Faversham & Oare Heritage Harbour Group

3 October 2019

Application by Cleve Hill Solar Park Limited for an Order Granting Development Consent for the Cleve Hill Solar Park Project

Heritage Harbour submission for Deadline 6

**Site Topography**  
Figure 7.4

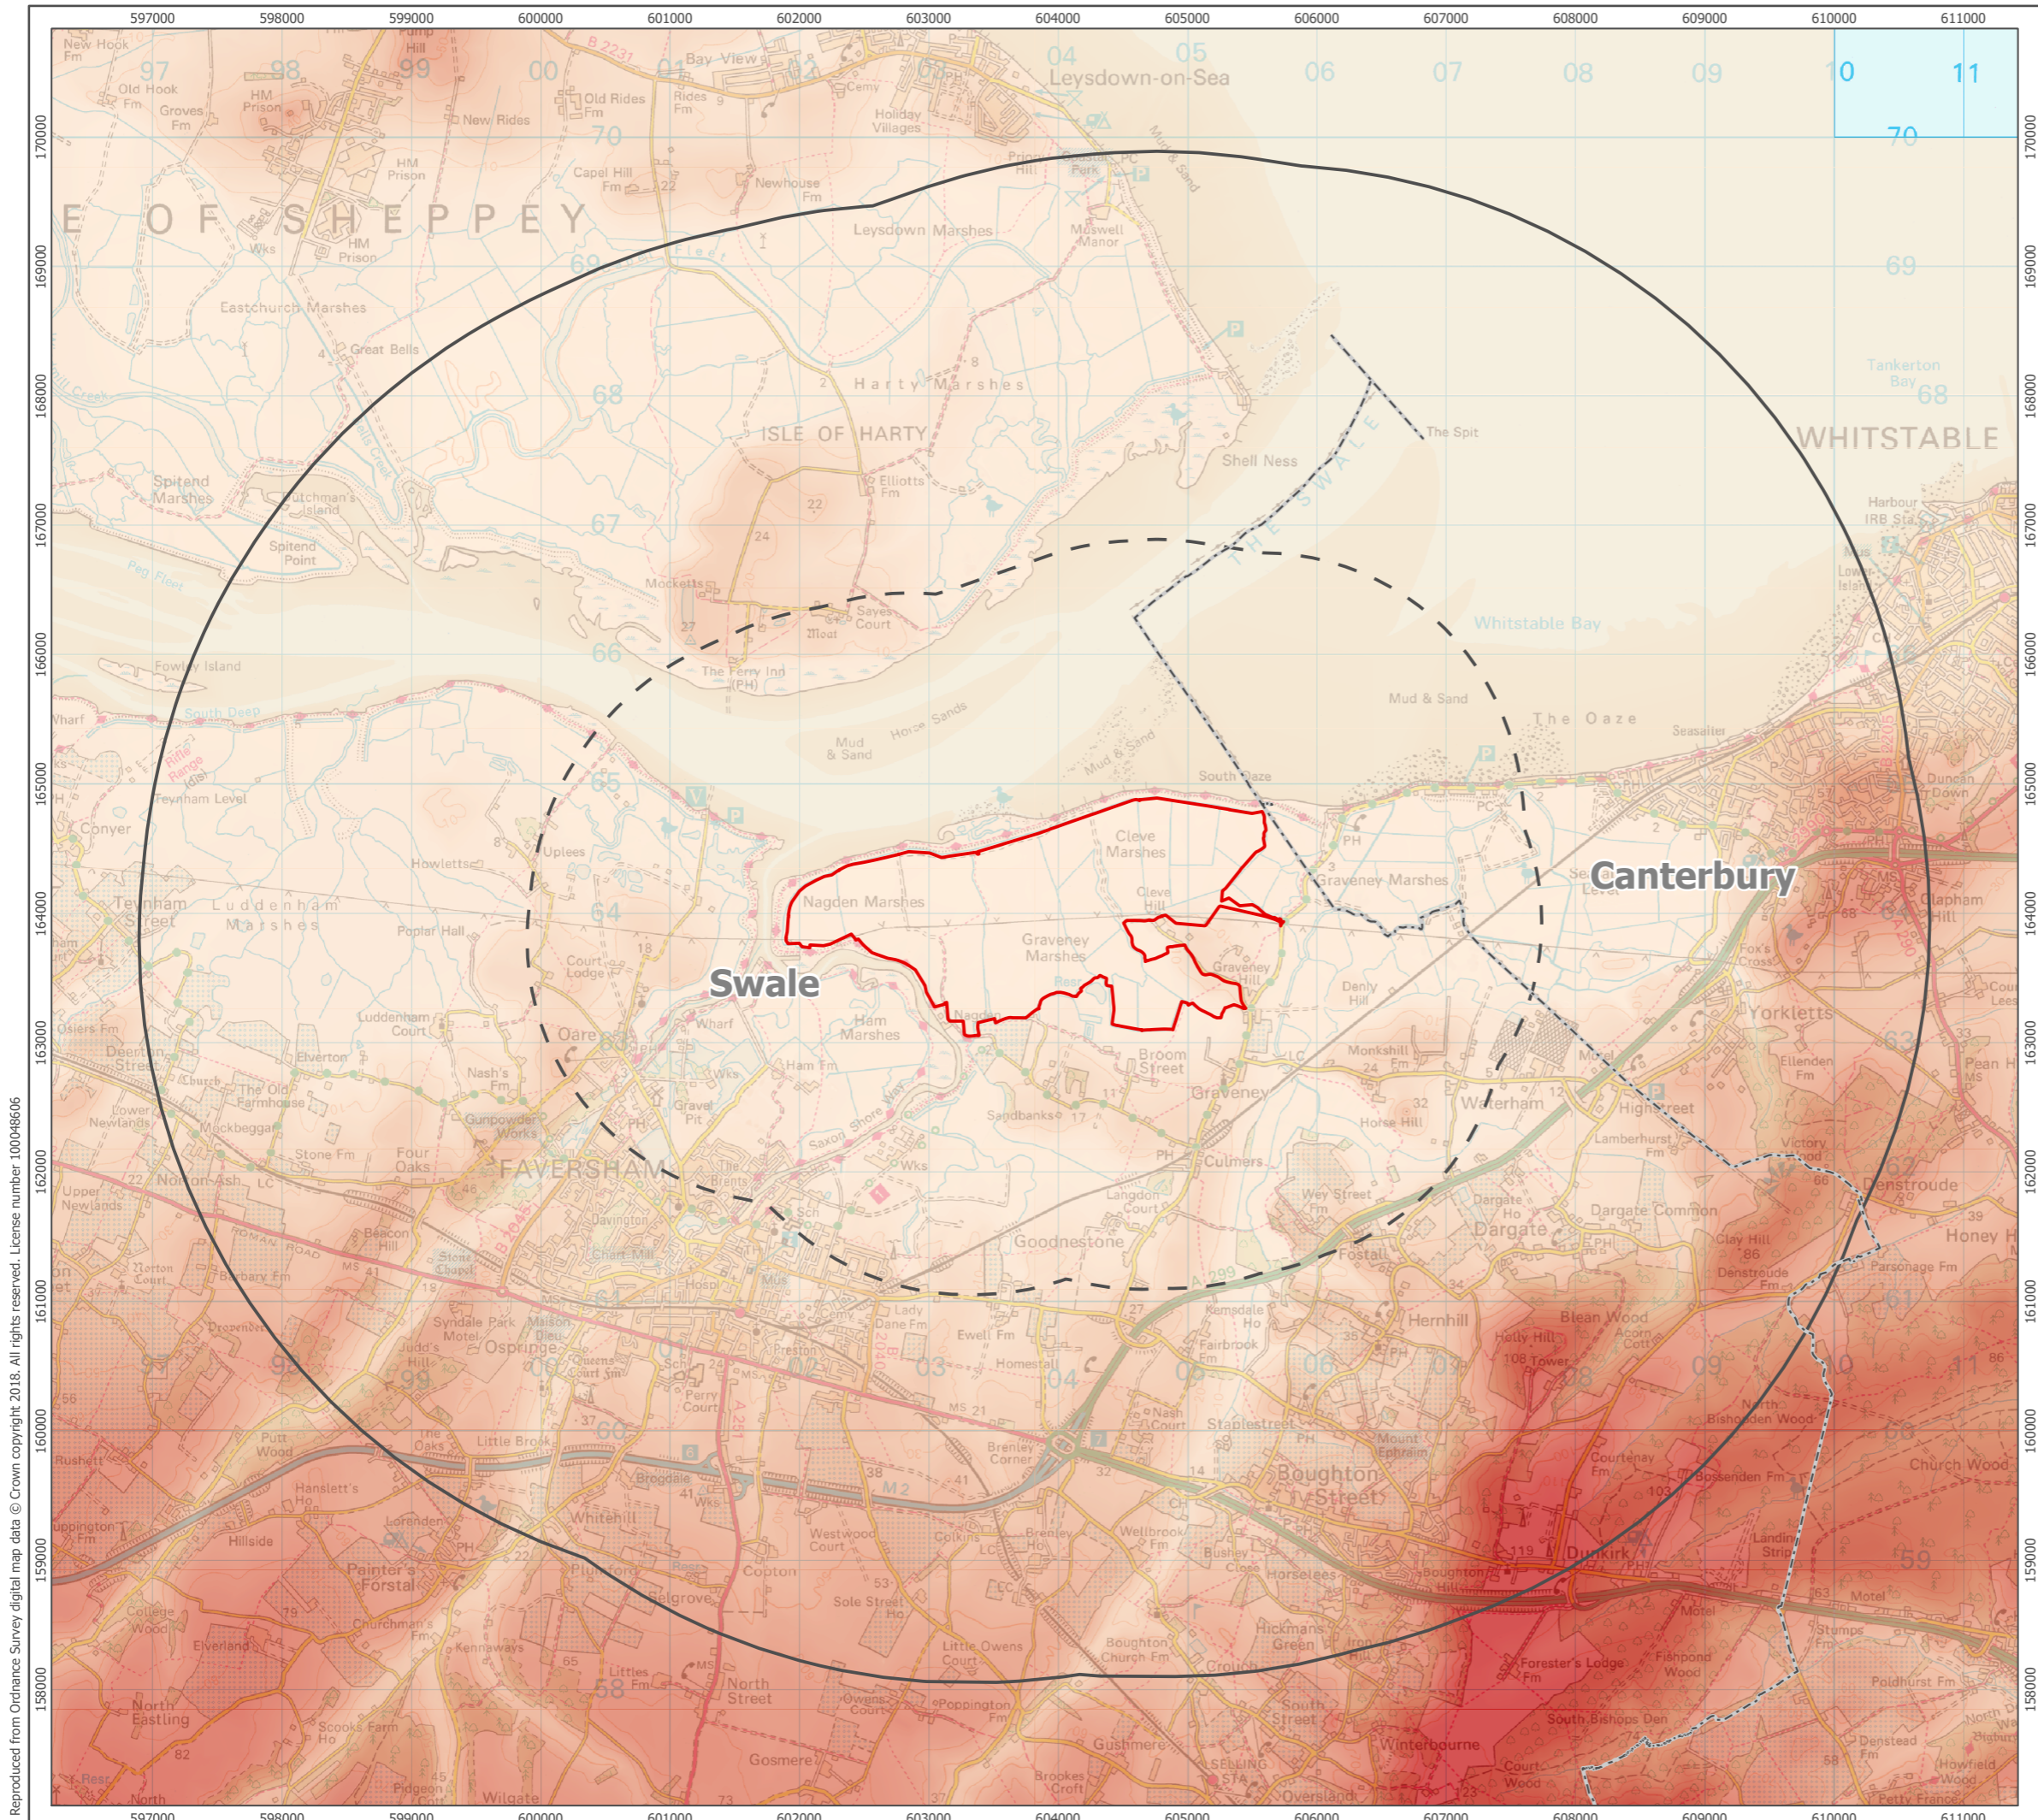
Following the Hearing, we re-examined the EA, but were unable to identify any specific topographic survey or data within that documentation. The only such information provided is in Figure 7.4, which represents an illustrative overview with no usable empirical data, as we had requested.

Submission item 56. This appears to be a larger scale version of the topographical analysis set out in Figure 7.4 but, as above, this represents an illustrative overview with no usable empirical data, as we had requested.
